TfNSW Reference: SYD22/01053/01

Client Reference: SSD-35609161

**EXHIBITION OF EIS FOR MIXED USE DEVELOPMENT IDENTIFIED AS GQ
PARRAMATTA – 12 HASSALL STREET, PARRAMATTA**

Title
B-GENERAL ARRANGEMENT PLANS
BASEMENT LEVEL 1 FLOOR PLAN

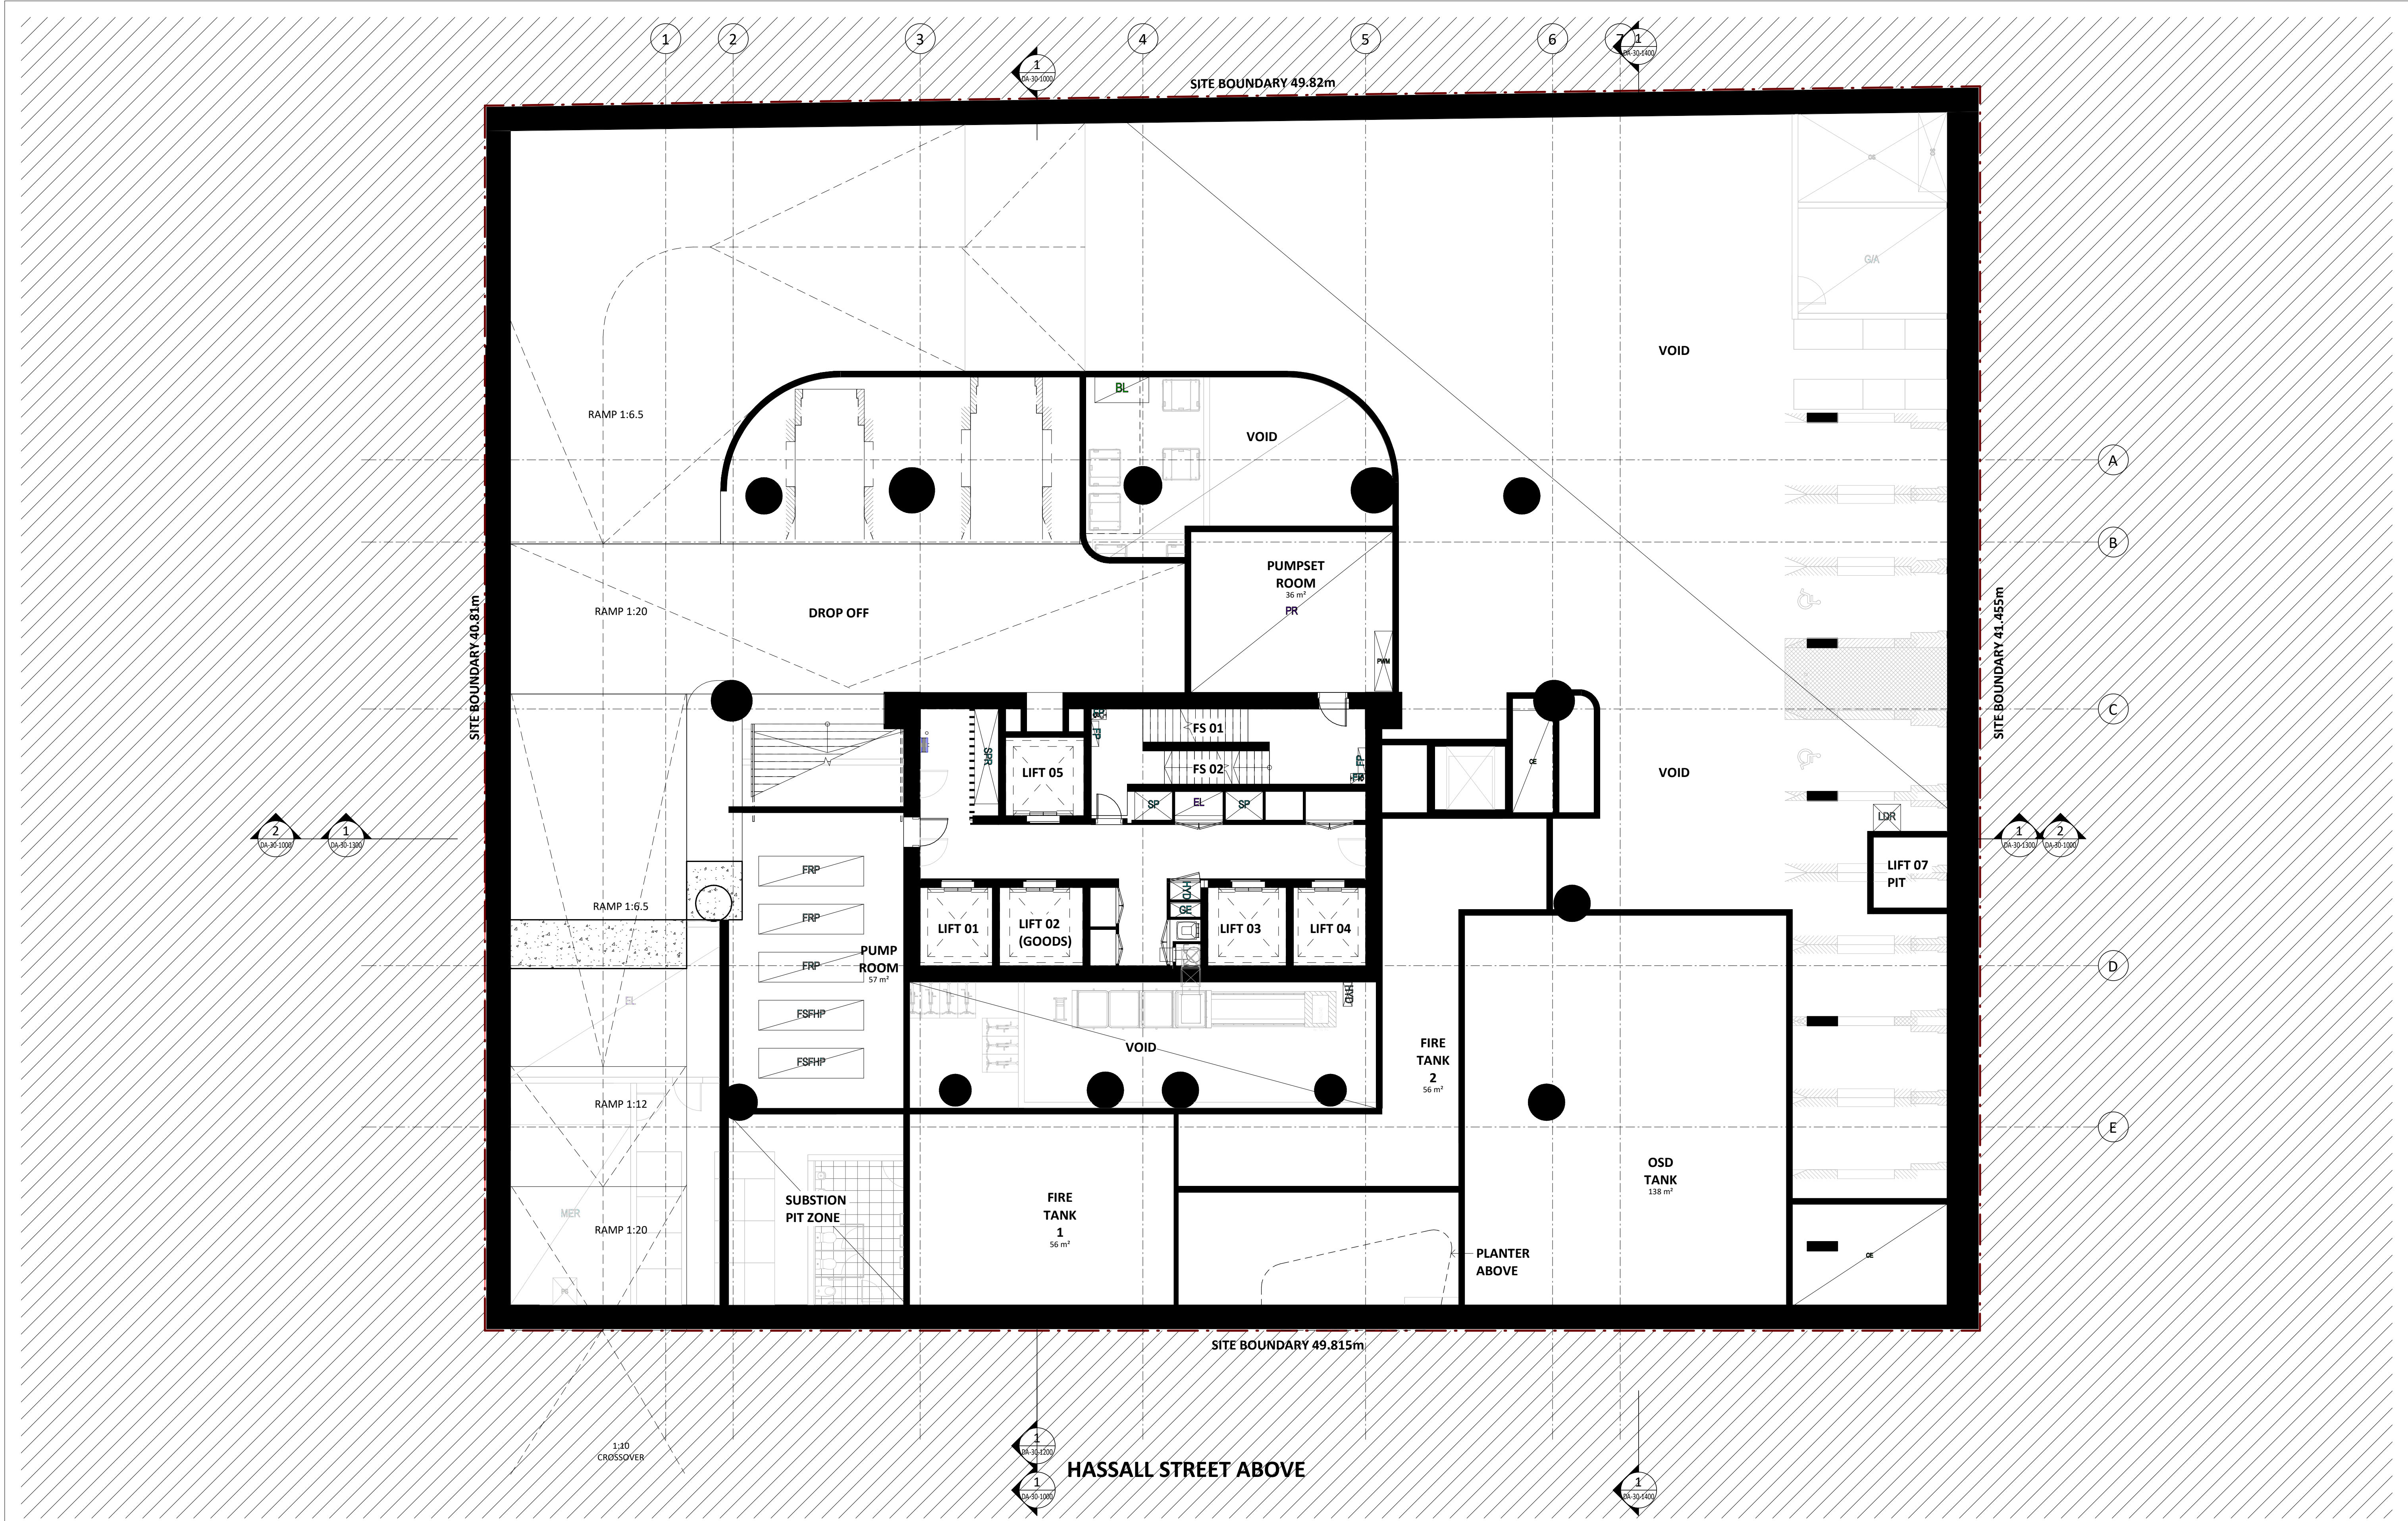
The vehicle swept path analysis in the Traffic and Parking Assessment report prepared to support the proposed development application shows swept path conflicts between a garbage truck and B85 vehicle during simultaneous travel within the ramp between Ground Level and Basement Level 1. A swept path analysis has not been provided at the development site access on Hassall Street, making it unclear if this issue also exists at the location of the site access.

A vehicle swept path analysis has also not been provided for vehicles entering and exiting the “drop off” area for the valet parking simultaneously on Basement Level 1M, as well as entering and exiting the valet parking spaces.

- It is considered that the location of the “drop off” area located off the vehicle ramp between the development site entry on Hassall Street and Basement Level 1 and adjacent to the curvature of the vehicle ramp may lead to vehicle collisions within the site due to poor sightlines for vehicles turning into and out of the “drop off” area;

- It is not clear how the “drop off” area and valet parking spaces would operate;
- It is not clear how the “drop off” area and valet parking spaces would be managed to minimise queuing into the vehicle ramp and development site access;

The vehicle swept path analysis must be updated to demonstrate nil swept path conflicts for all onsite vehicle manoeuvres. The swept path analysis should also demonstrate that vehicles are able to enter and exit the “drop off” area simultaneously and within the valet parking area without any swept path conflicts. It is also requested that the applicant clarify the vehicle class of the garbage truck used in the swept path analysis.

As part of the Response to Submissions, it is requested that the applicant undertake a road safety audit for the design and operation of the “drop off” area and valet parking spaces and that any necessary design and operational changes to the “drop off” area and valet parking spaces be made to mitigate any identified road safety impacts.

It is also requested that the applicant provide details on the requirement for the “drop off” area and valet parking spaces, how they are proposed to be operated, and how they would be managed to minimise queuing into the vehicle ramp and development site access.

Title
B-GENERAL ARRANGEMENT PLANS
LEVEL 00 GROUND FLOOR PLAN

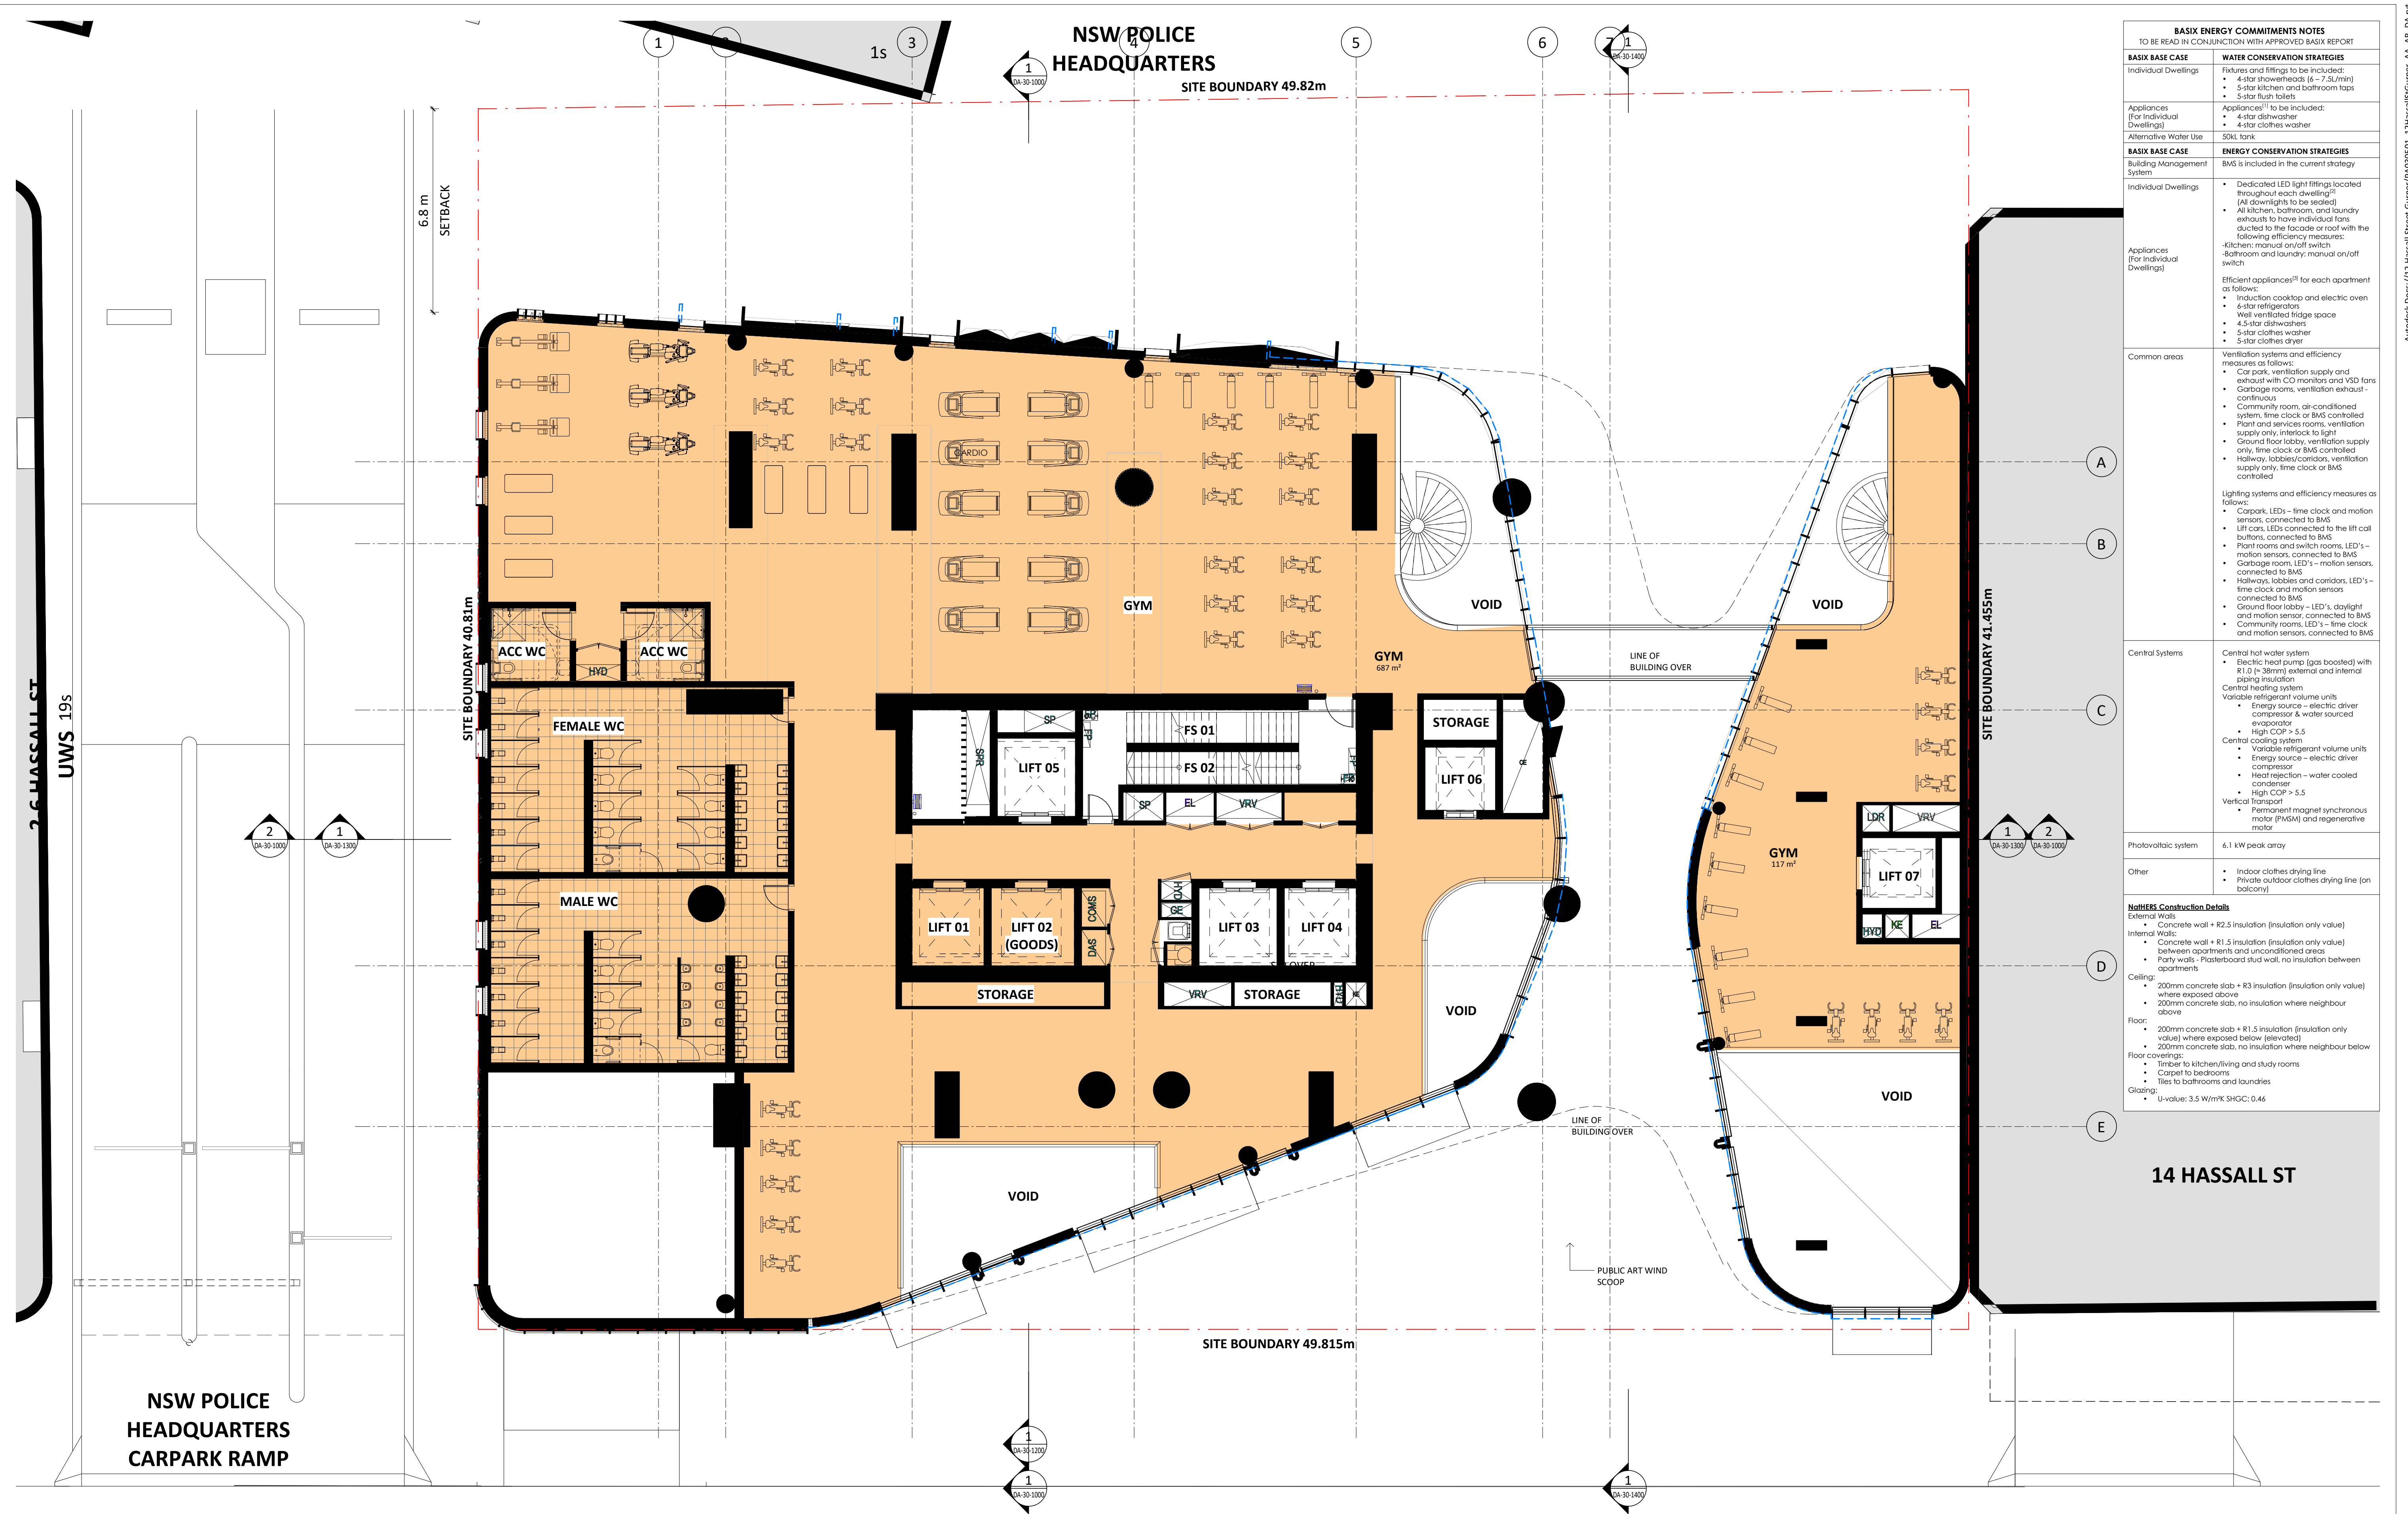
The architectural drawings prepared to support the development application retain the existing indented on-street parking bay along the development site’s Hassall Street frontage. It is advised that retaining the indented parking bay does not produce a good pedestrian outcome, with pedestrians needing to weave in and out due to the changing alignment of the footpath on both sides of the development site.

It is requested that the applicant remove the existing indented on-street parking bay along the development site's Hassall Street frontage and widen the pedestrian footway in its place as part of the proposed development.
